CITY OF ALBUQUERQUE
 PLANNING DEPARTMENT
 DEVELOPMENT REVIEW BOARD

Project# 1009375

12DRB-70252 MAJOR – SITE DEVELOPMENT PLAN FOR BUILDING PERMIT

**HYDROLOGY DEVELOPMENT SECTION
DEVELOPMENT REVIEW BOARD MEMO**

C001

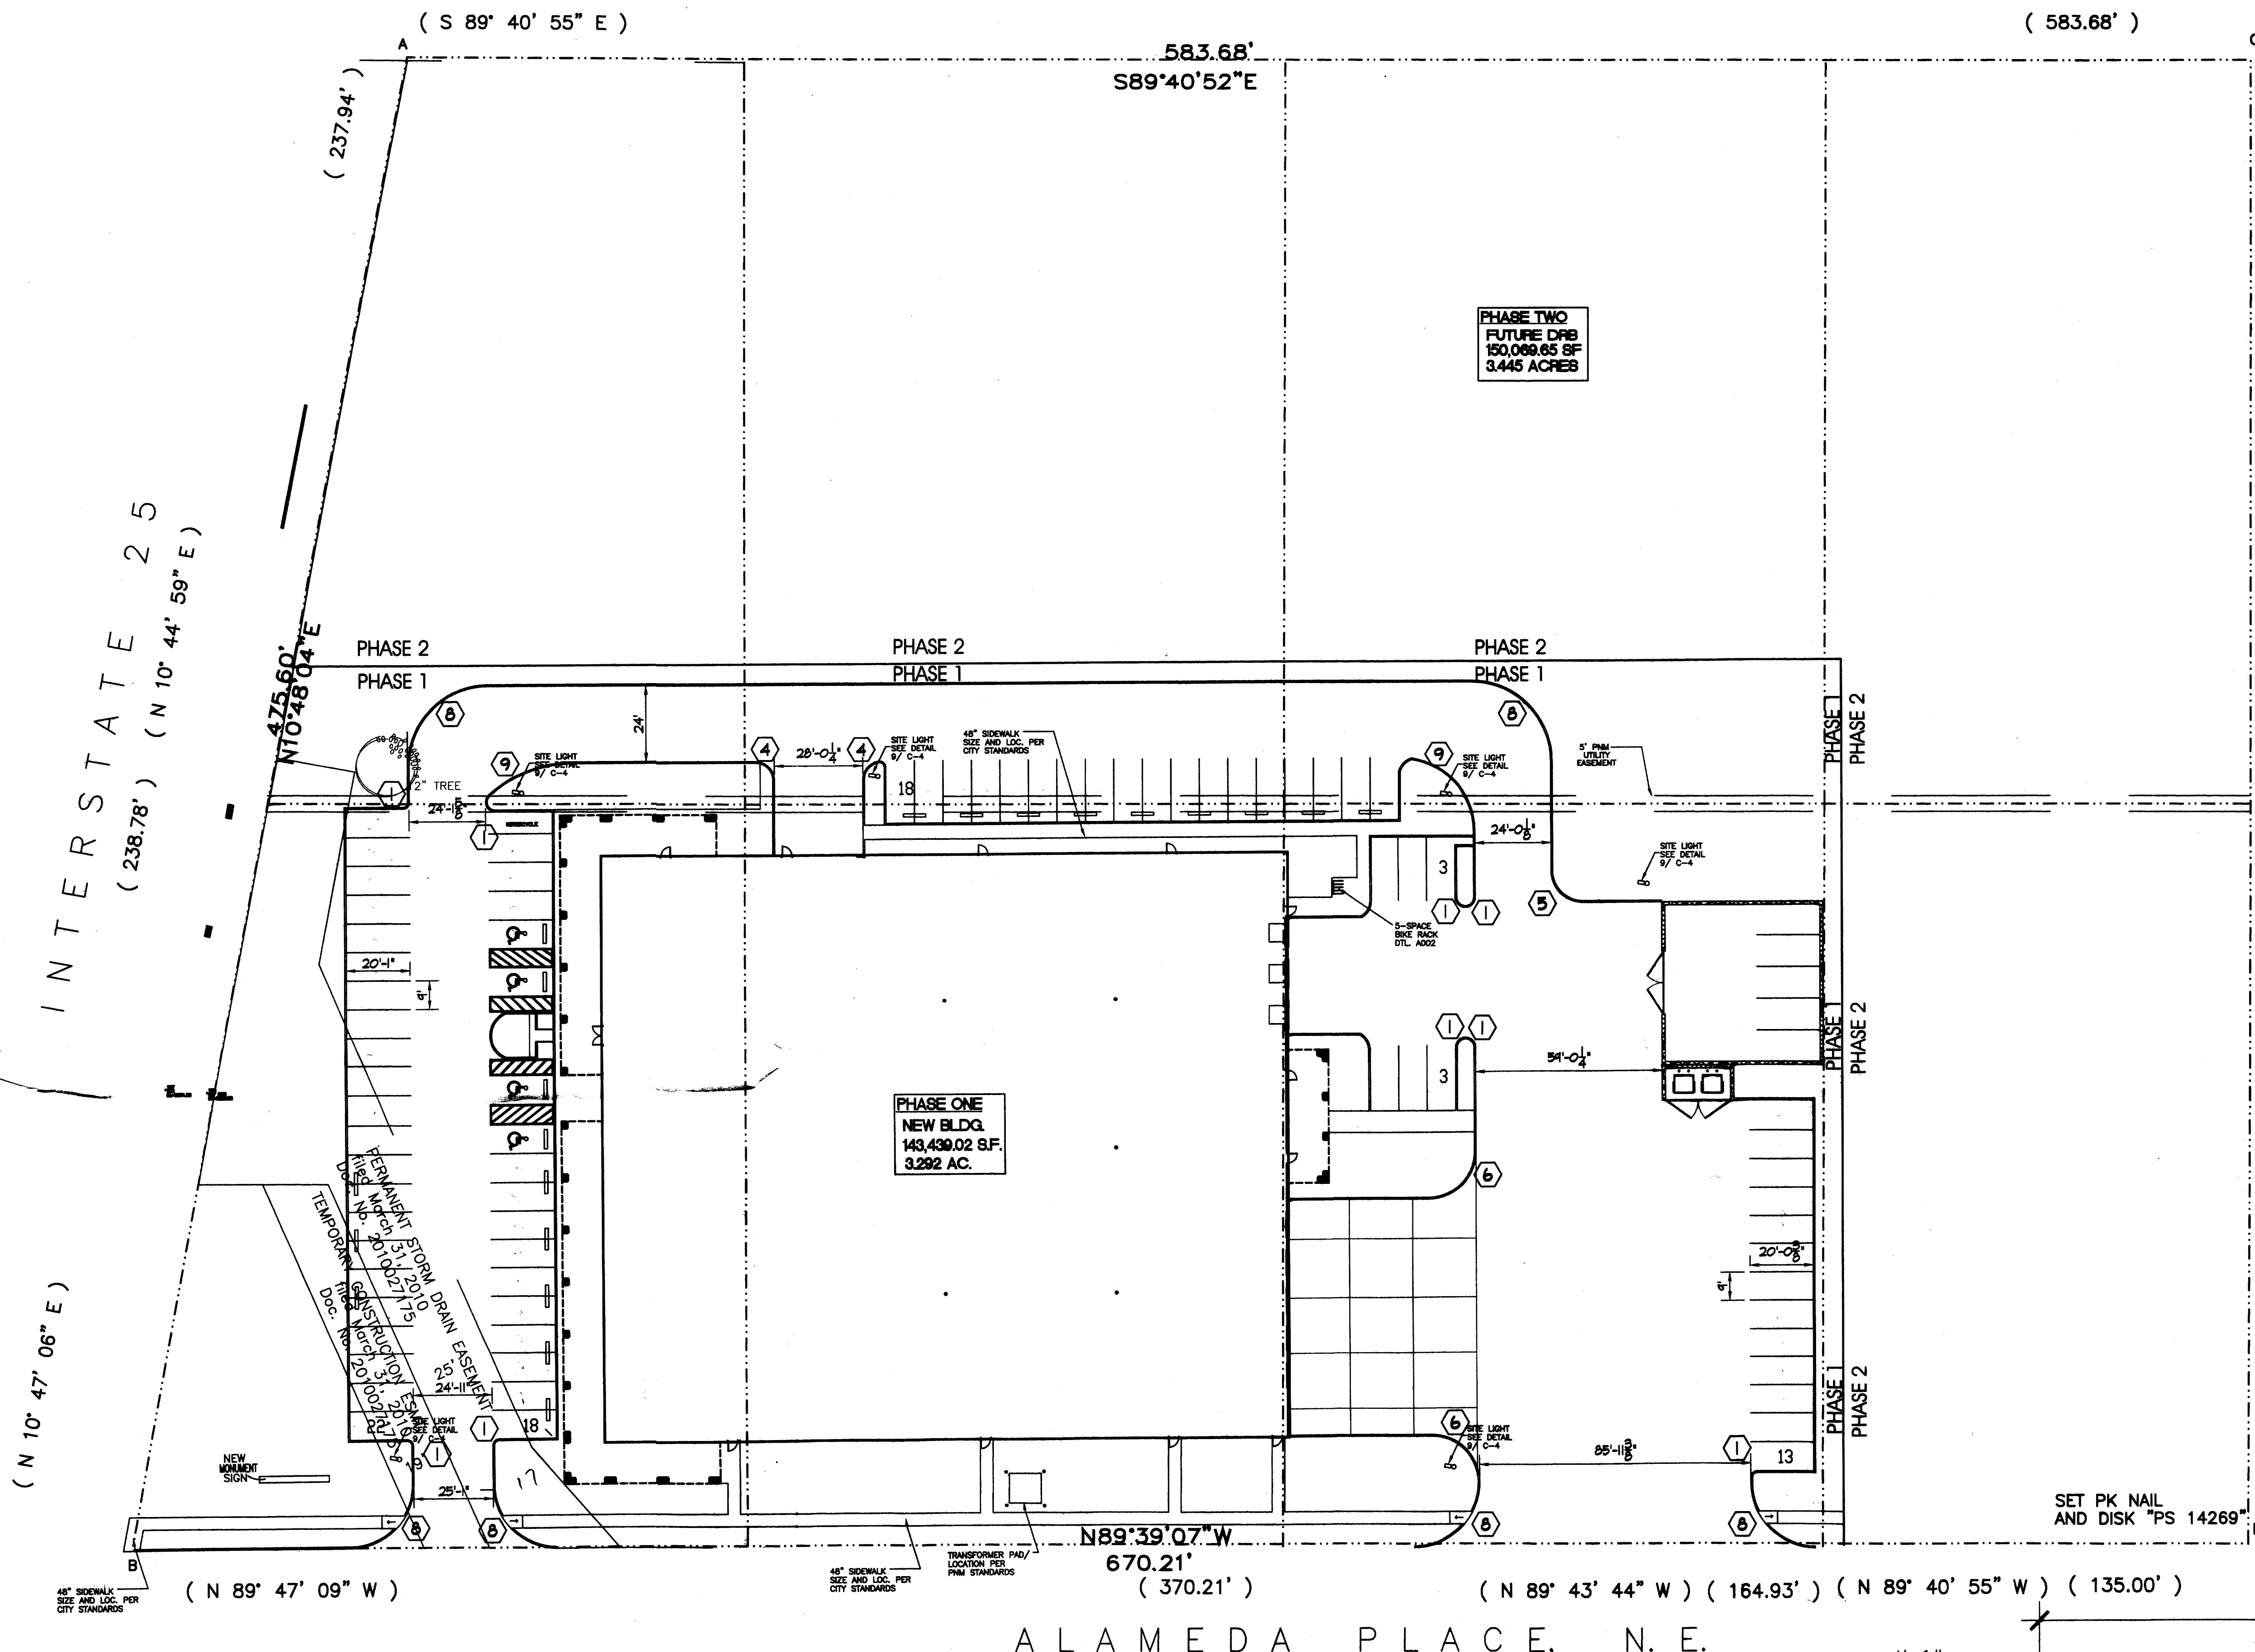
Will this property be re-plated? There are existing
Lot lines in the middle of the building.

Public sidewalk easement will be required along
Alameda Place.

Where are the proposed road improvements along
Glendale and San Pedro.

What is north portion of the site being used for.

Provide an exhibit showing the location of sidewalk and defining the distance from face of curb to the property line. Right of way dedication may be required.

All public sidewalk located outside City right of way must be located within a public sidewalk easement. A 50-foot wide driveway is the maximum permitted (see *Development Process Manual*, Chapter 23, Section 6, Part B).

Is there a replat associated with this site? If lot consolidation is not proposed, cross access easements are required.

A 6-foot wide, ADA accessible pathway is required from the roadway to the building.

For passenger vehicles, the minimum end island radius is 15 feet.

Define the width of all ADA accessible parking stalls and aisles.

Sidewalk (6-foot wide) is required along the frontage road.

Define the width of all right of way adjacent to this site.

Define the width and length of all parking stalls.

Show all ramps and provide details.

Label Glendale Avenue.

Show all lot lines.

Define all aisle widths.

Sheet Title:
CONCEPTUAL GRADING AND DRAINAGE PLAN

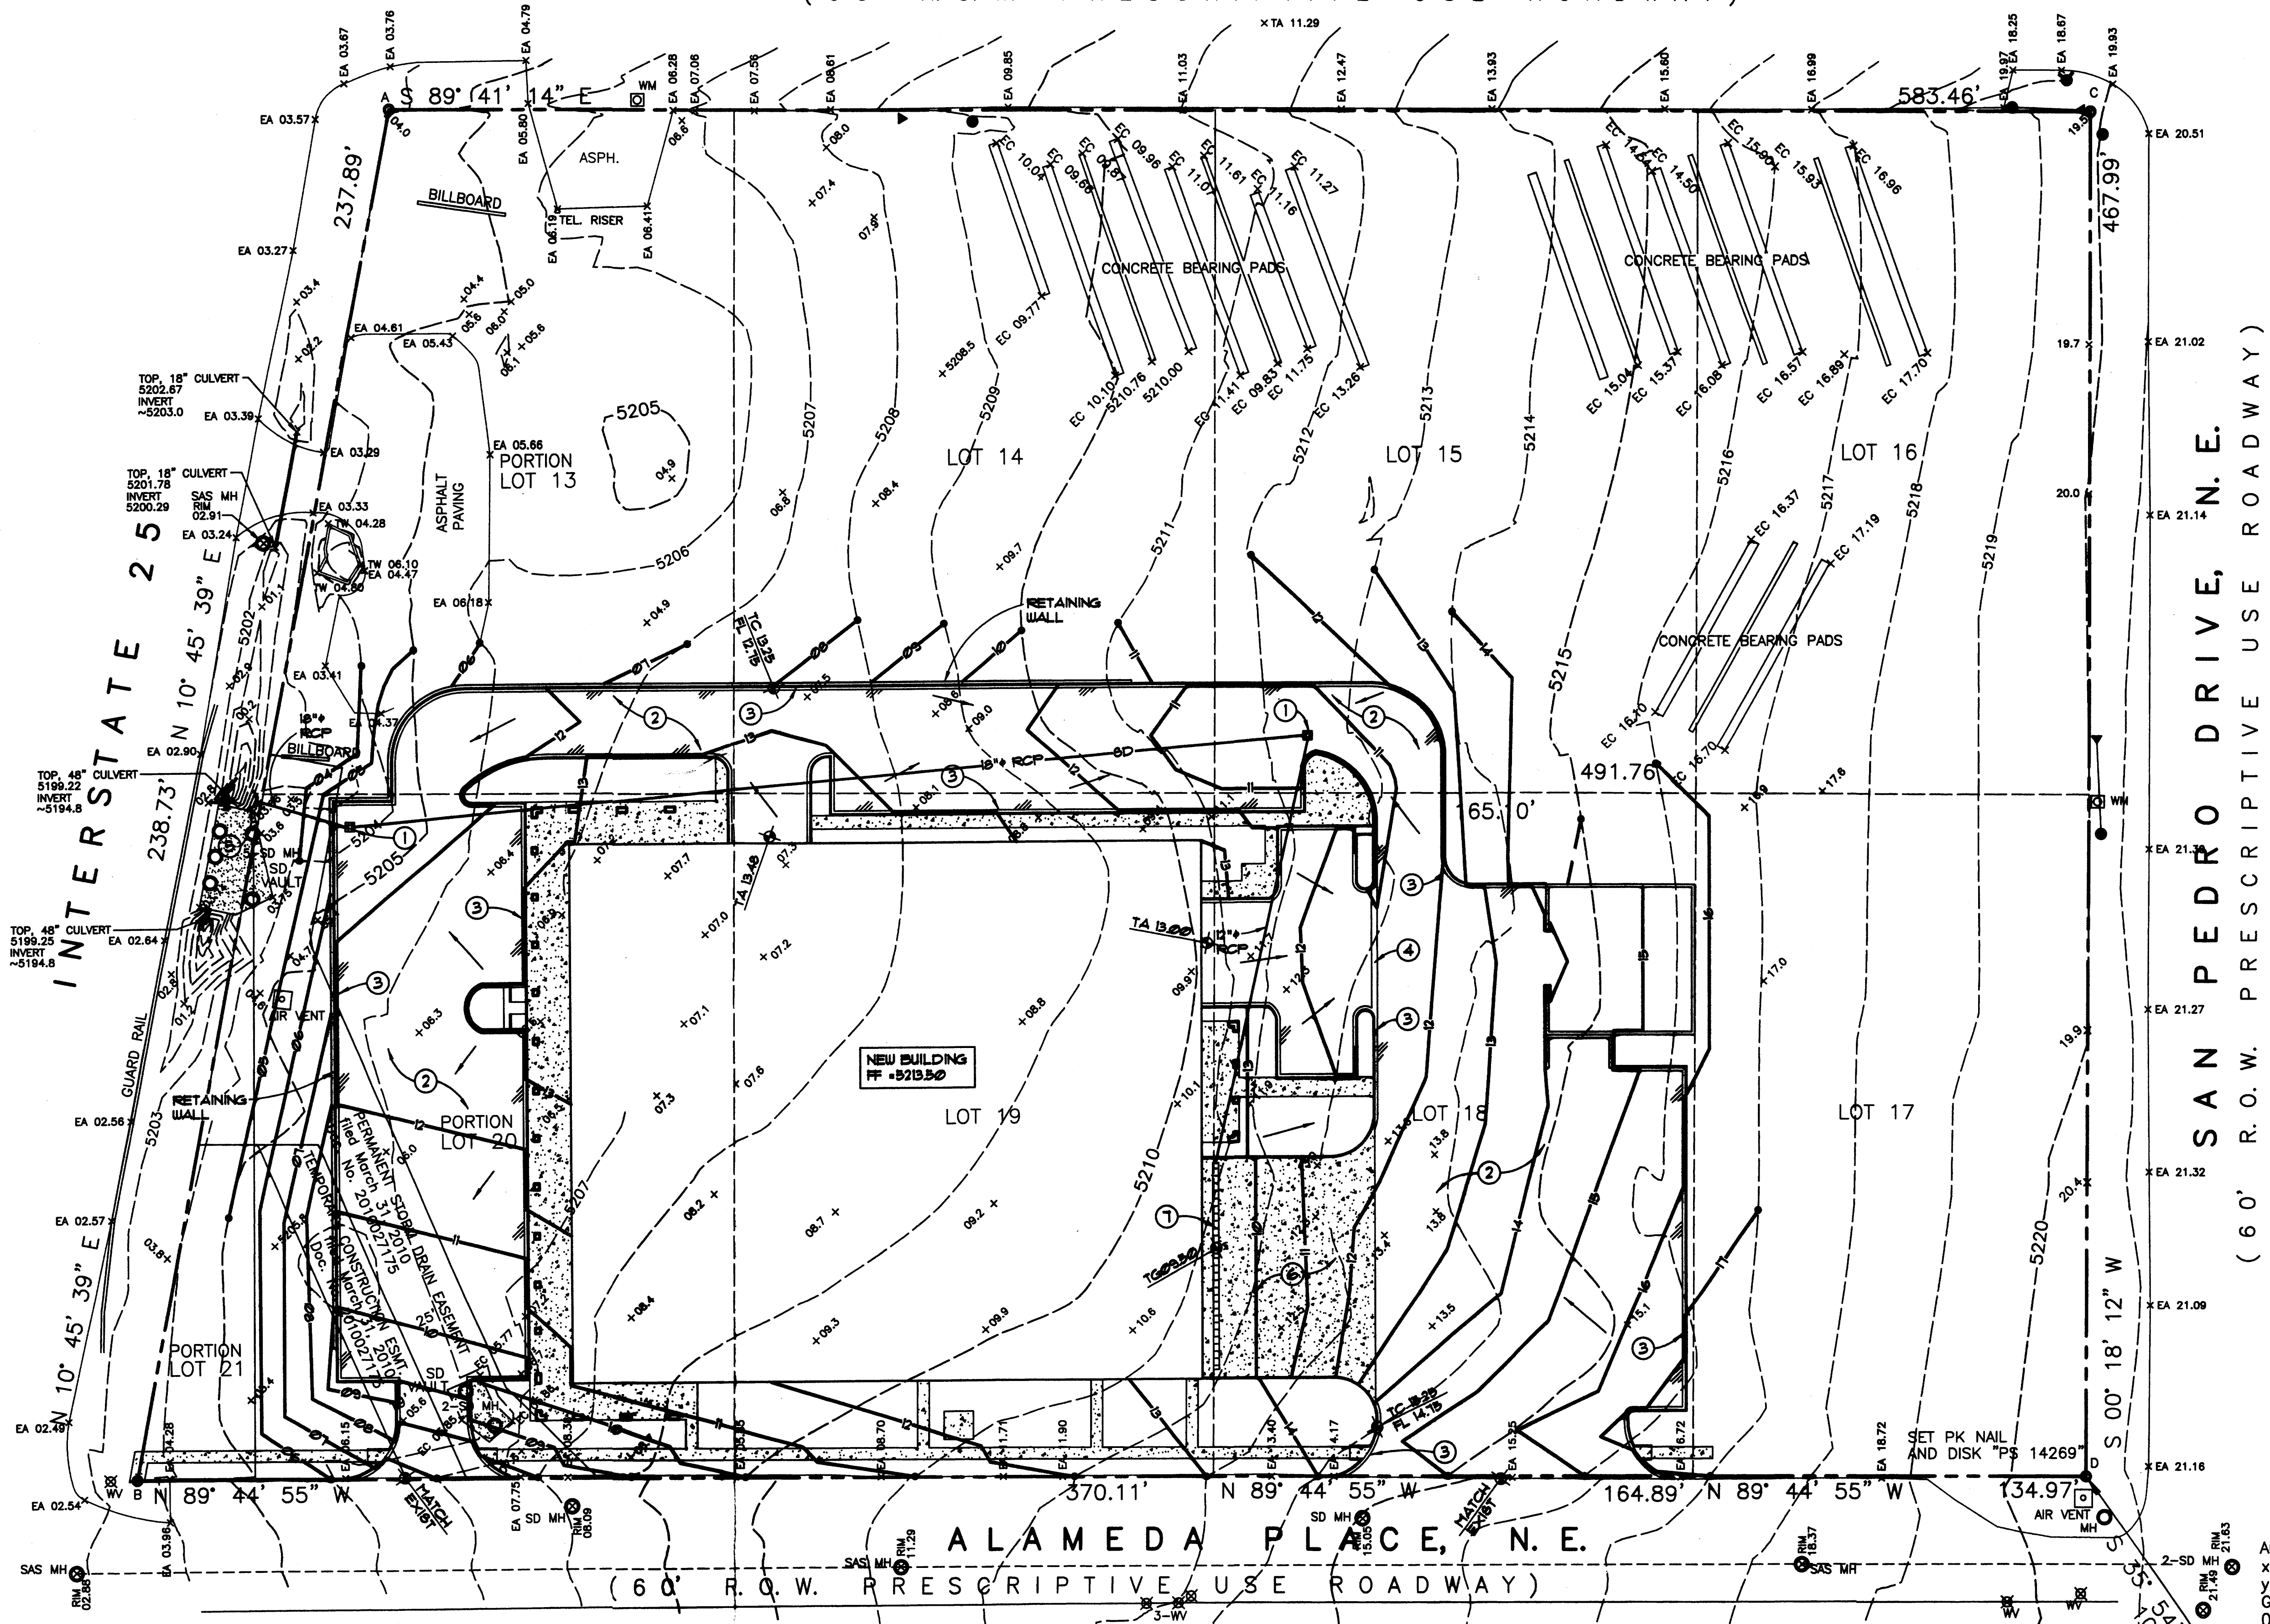
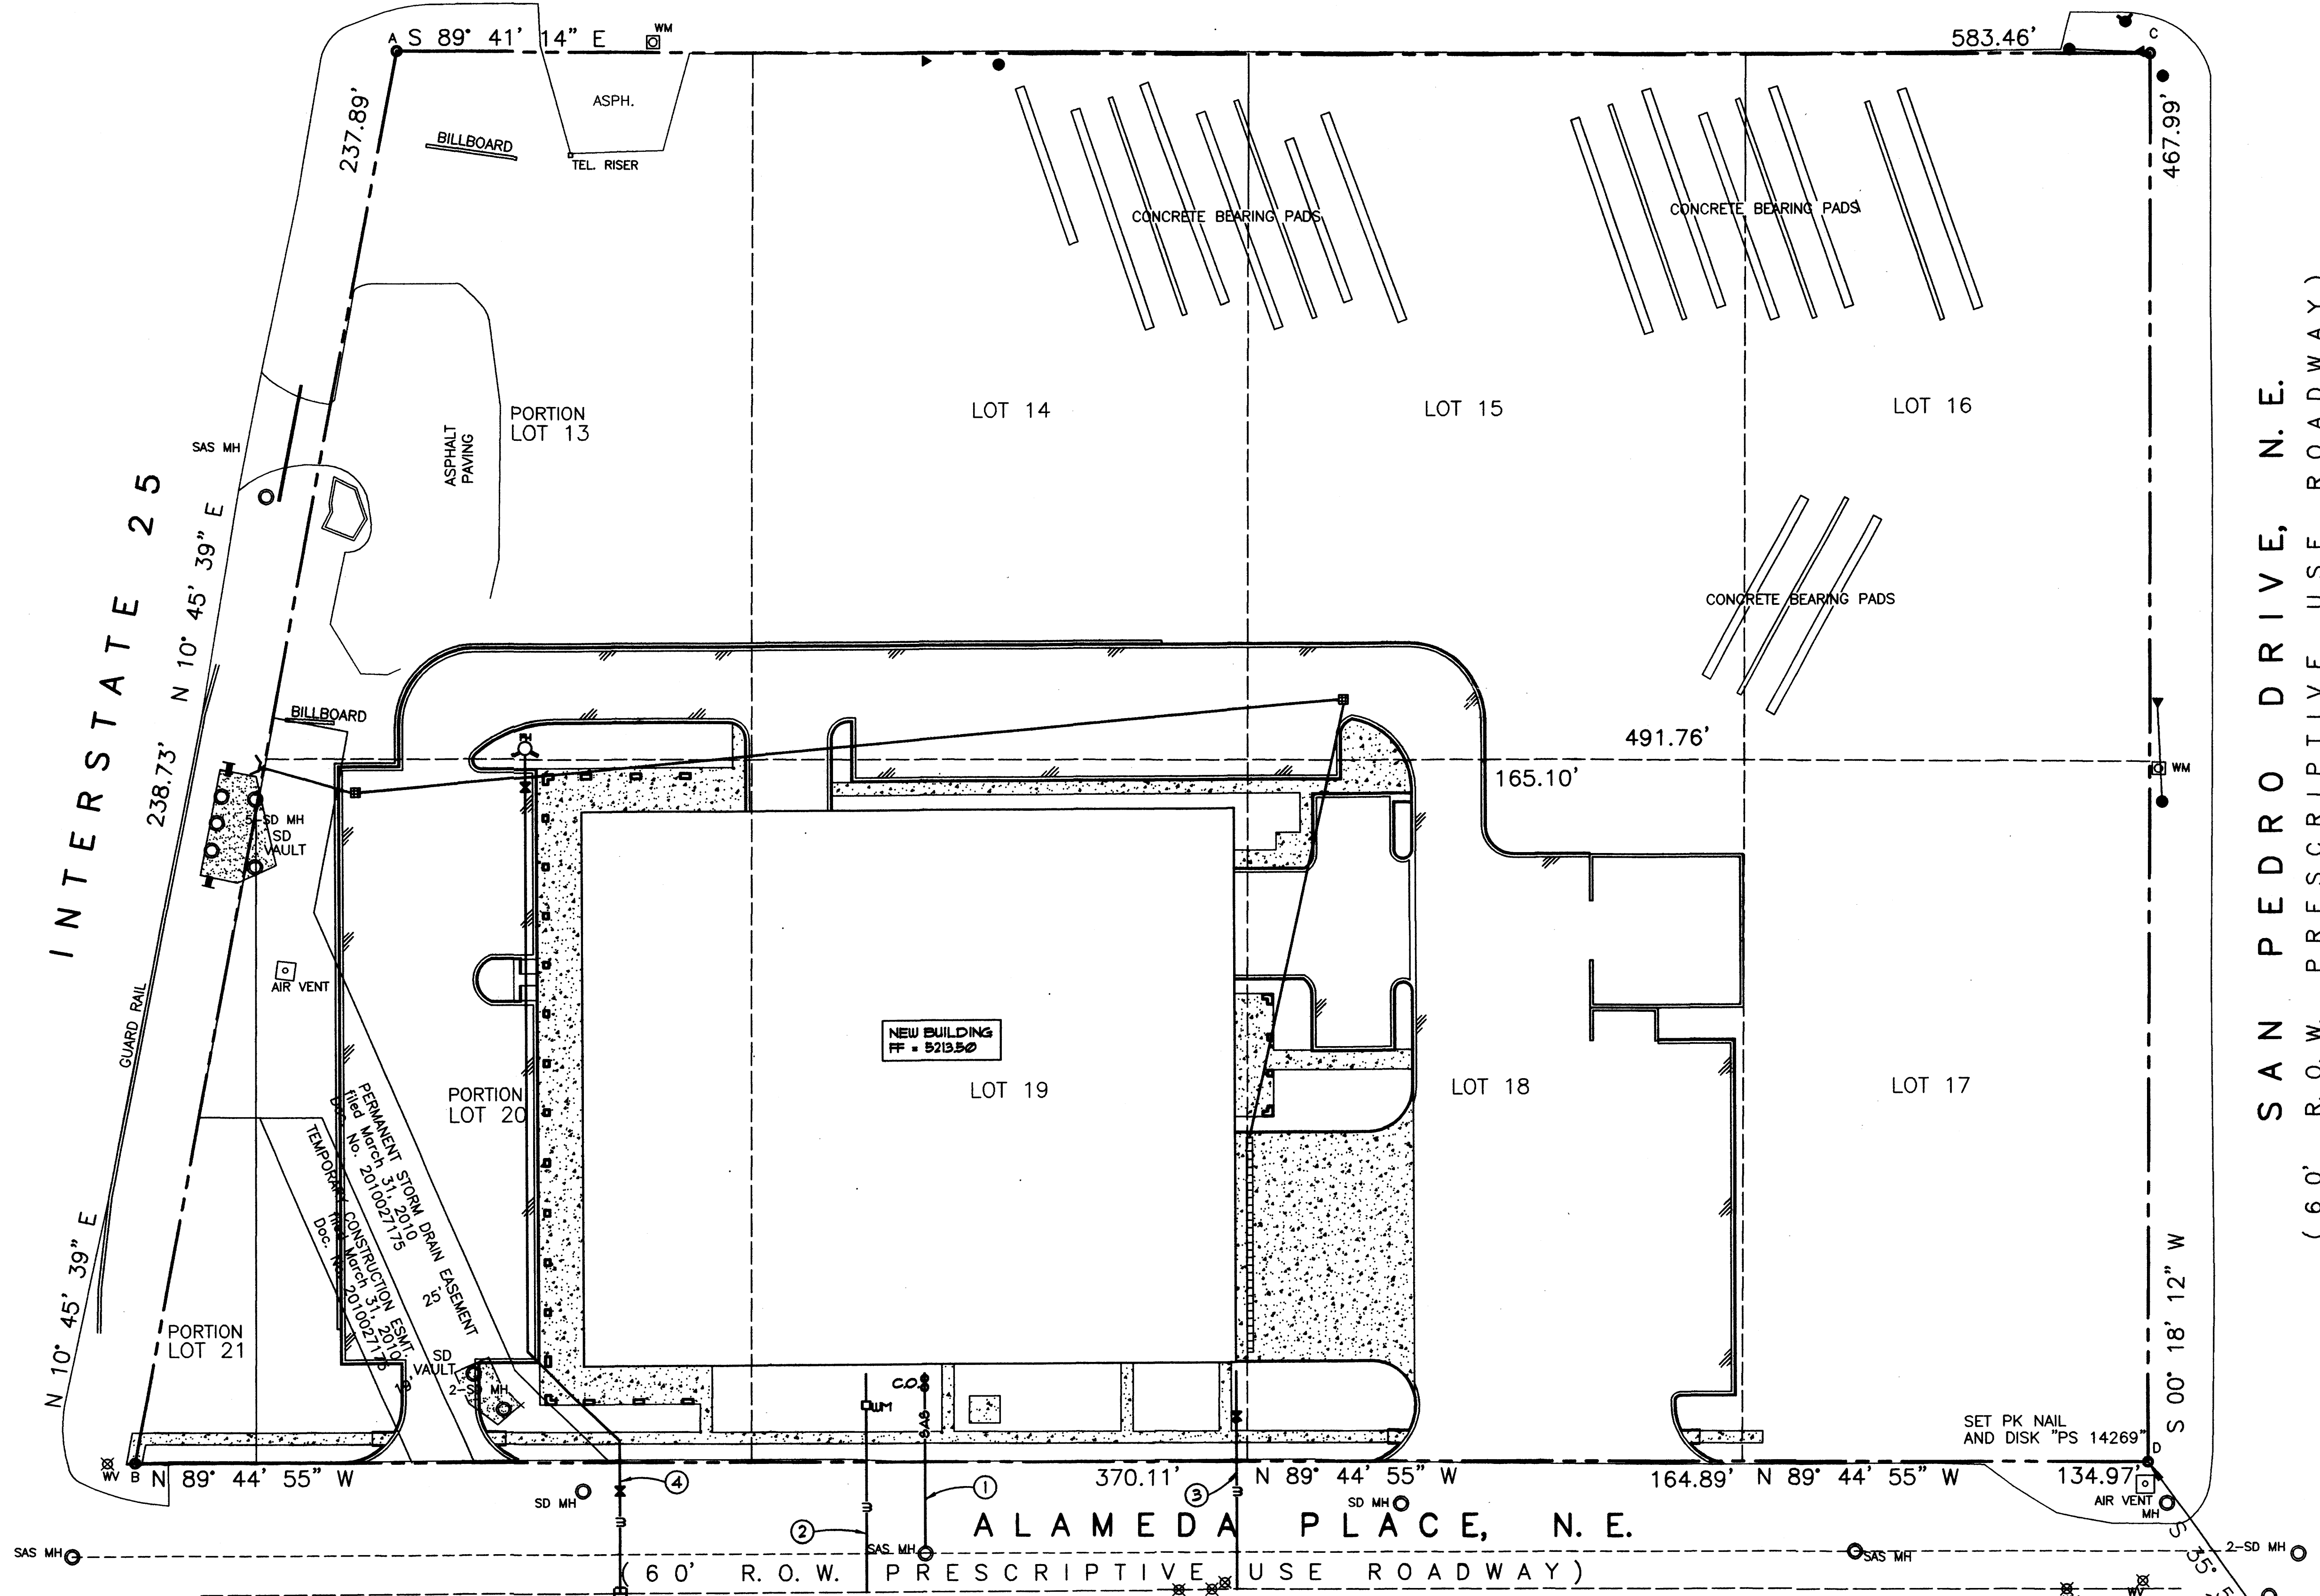
An approved Grading and Drainage Plan is required.
NM DOT approval will be required.
